Lincolnshire County Council supplemental response indicated in the document submitted for Deadline 5- sections omitted from the original document

1. Lincolnshire County Council comments on Lincolnshire Coastal Country Park

2. Lincolnshire County Council comments on Outline Soil Management Plan (Rev B)- (paragraph 68)

**Figure 4: Indicative cross section of onshore export cable corridor**

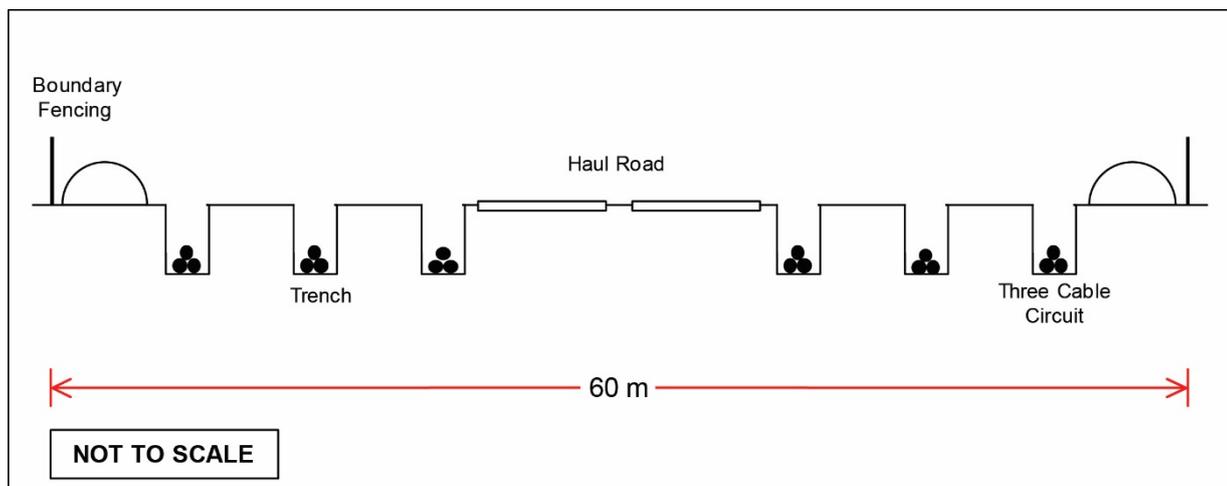
- 2.4 The applicant has indicated at paragraph 3.6 that the working width will generally be no wider than 60 metres. The County Council are of the view that the DCO and associated compulsory acquisition of land will, other than for a short stretch of greater width, be limited to the 60 metre width

and therefore no excess can be used or acquired without the relevant landowners consent.

- 2.7 The applicant has indicated at paragraph 3.7 that within the documentation that a temporary haul road will be constructed, however the documentation submitted shows the width of the road to vary from 6.0m (para 3.62) to 6.8m (SOR para 4.36).
